Light Valley Solar

Supporting Environmental Information Report (Change Application)

Document Reference: EN0110012/APP/LVS/08.43

October 2026

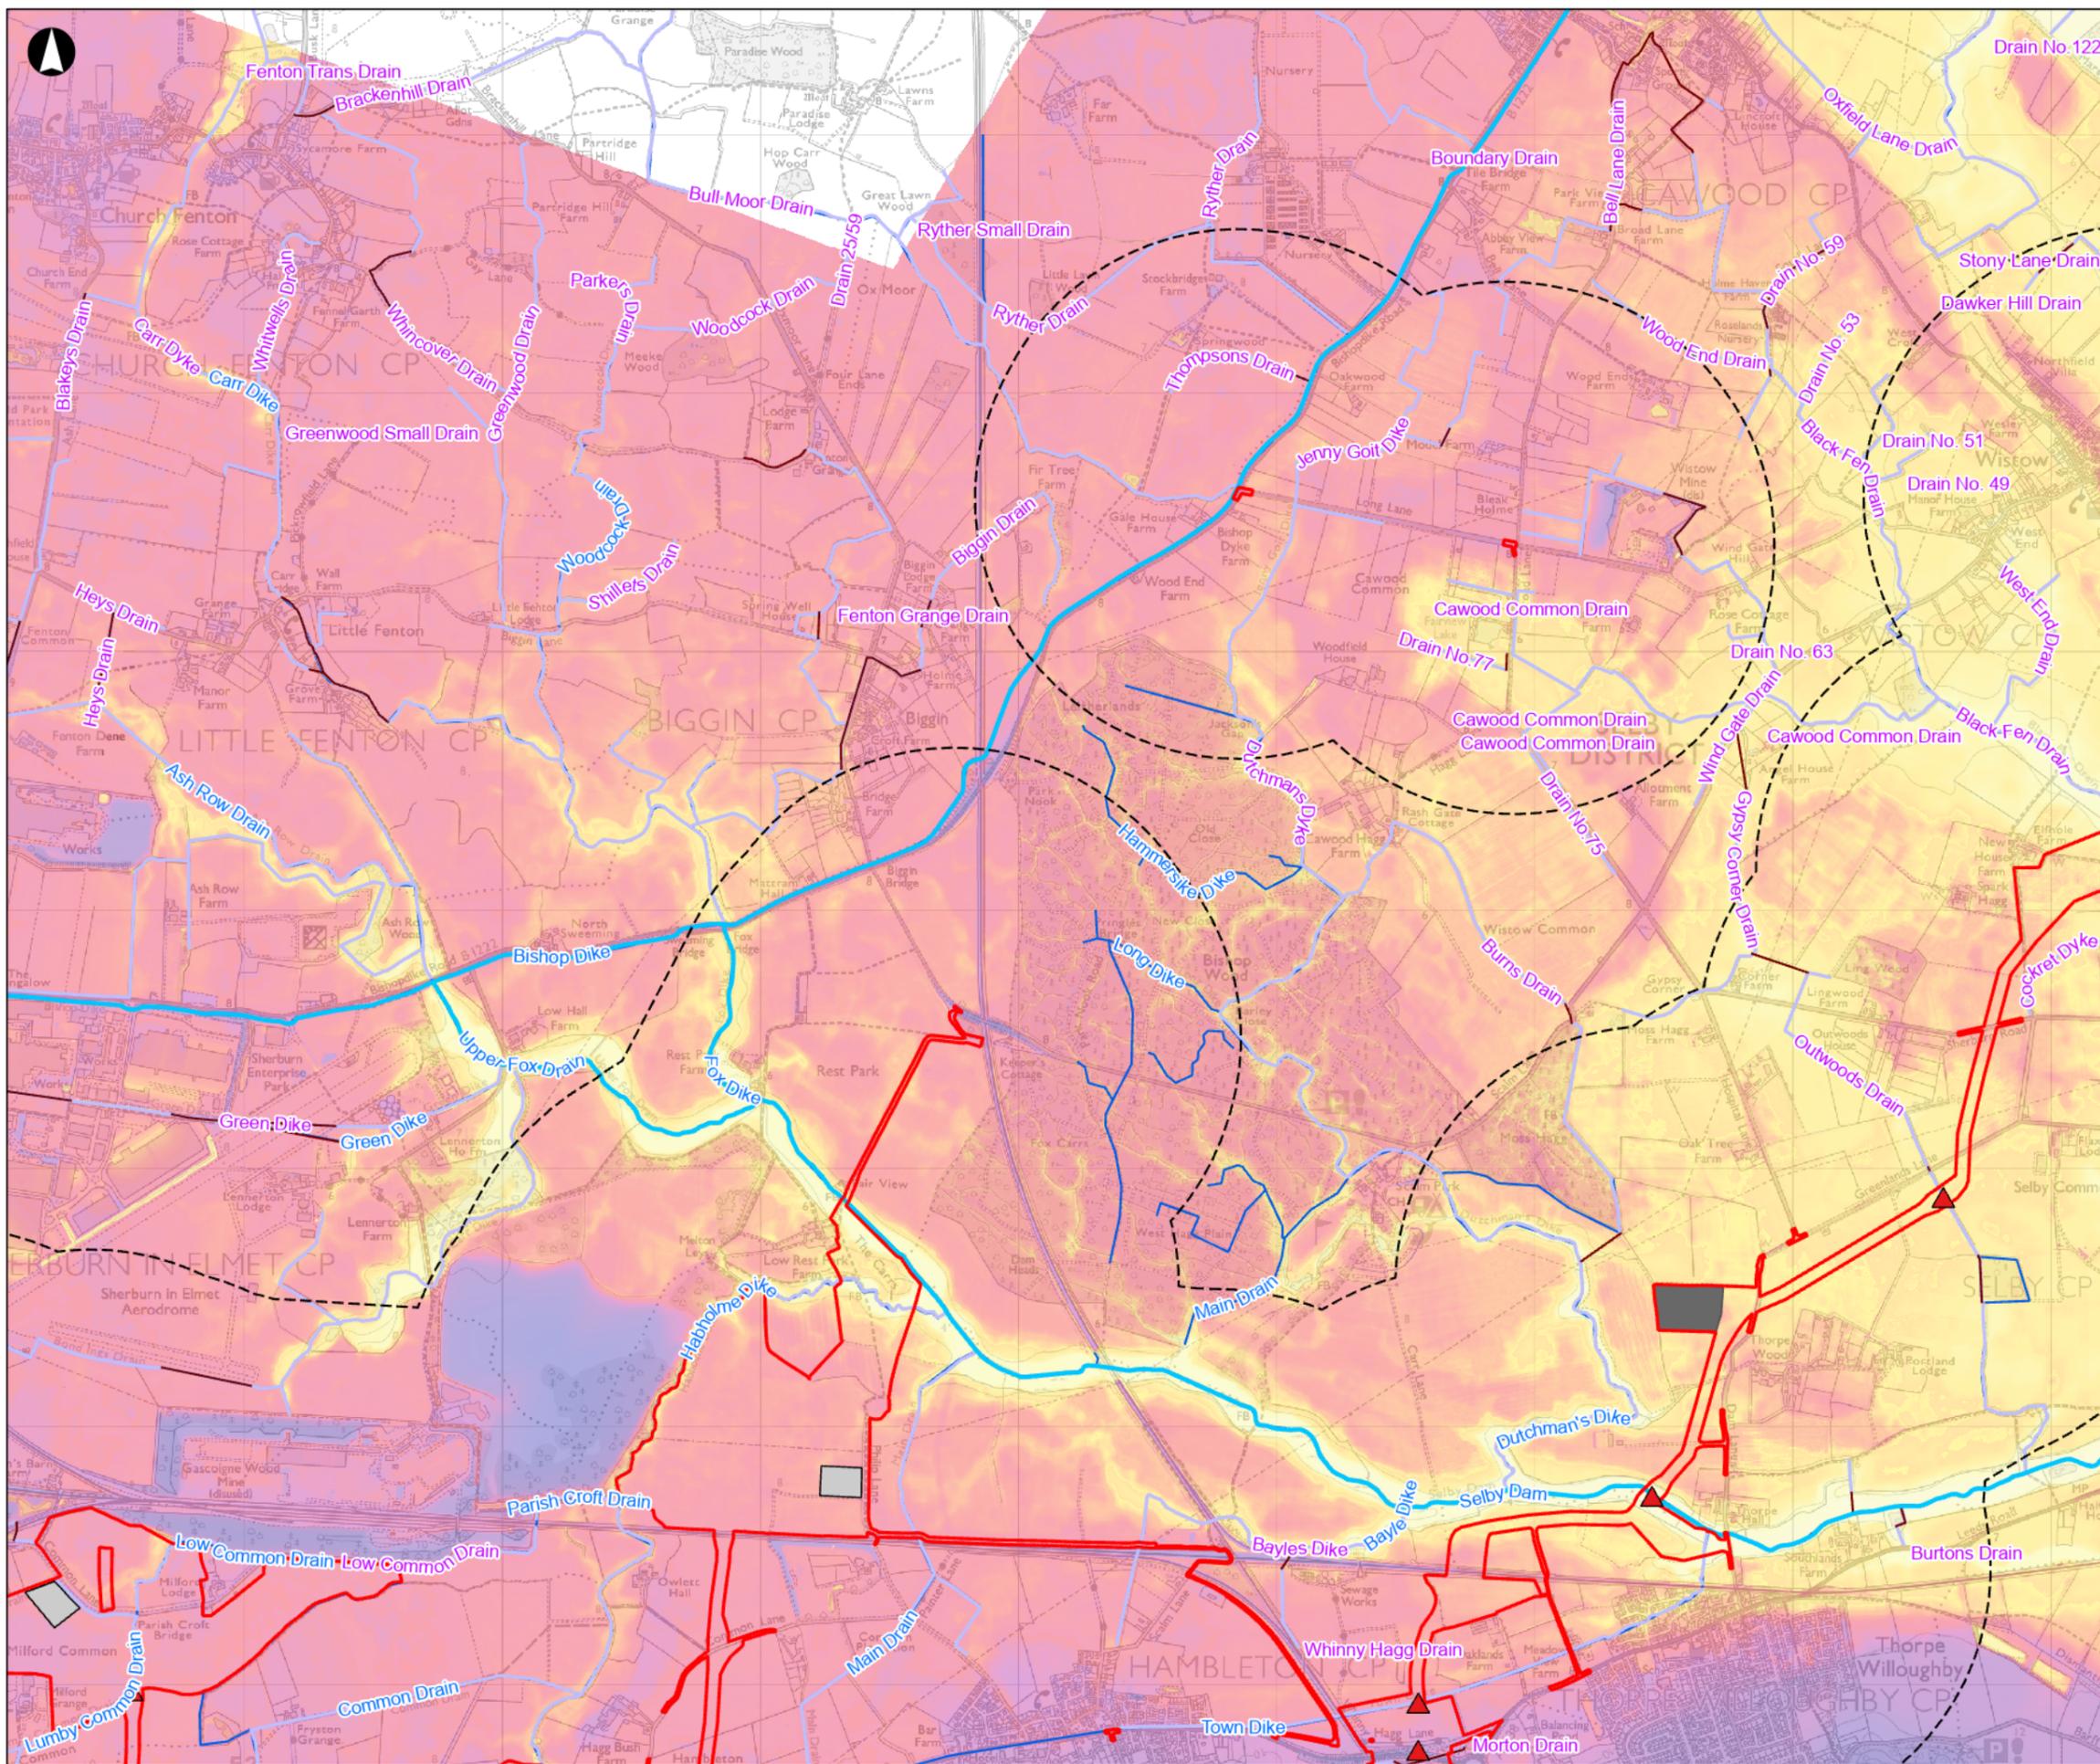
- 2.3.3 As set out within the Applicant Technical Note Plot Size **[REP2-115]**, this section on the Cable Route Corridor is constrained by an Internal Drainage Board Ditch (IDB) ditch (refer to ES Volume 2, **Figure 15.1 Surface Water Features [APP-115]**) which the Applicant has committed to cross using a trenchless solution (refer to ES Volume 2, **Figure 2.5 - Avoidance Areas [APP-062]**). The breadth of the Cable Route Corridor in this location allows for micro siting of the cable and trenchless works during the detailed engineering design work. The Order Limits also captures an existing culverted crossing in the west of the Cable Route Corridor which would be used for access where practicable, rather than introducing new temporary culverts.
